PROPOSED NORTHCONNEX M1 / M2 TUNNEL PROJECT - Application Number - SSI 13_6136
We object to many aspects of this project

MOTORWAY OPERATIONS COMPLEX - SOUTHERN VENTILATION FACILITY - SECTIONS  
M1-M2-5000-DR-JD-0525

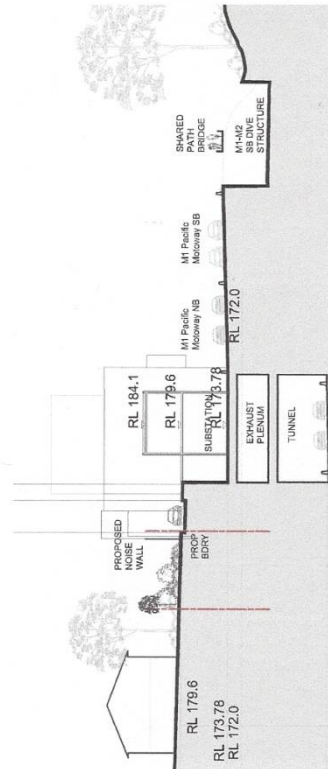
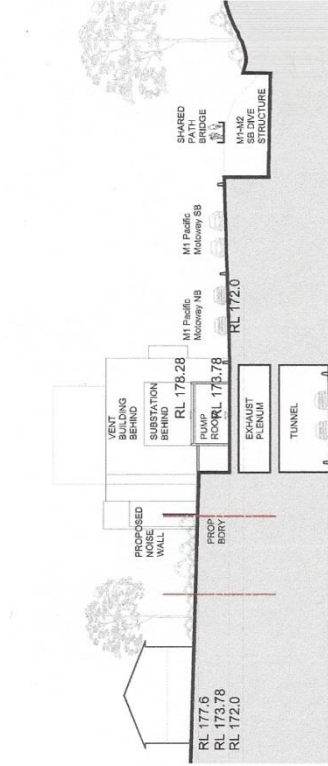
1. The Environmental Impact Statement (EIS) does not show any connection between the ventilation stack and the southbound tunnel which is 250 metres away. Will the polluted air be allowed to flow like an invisible sewer through West Pennant Hills, North Rocks, Carlingford and Beecroft?
ACTION: Provision of diagrams and detailed description of what ventilation is proposed for the southbound tunnel at the Southern Interchange. We would like the opportunity to lodge further submissions once that has been provided.
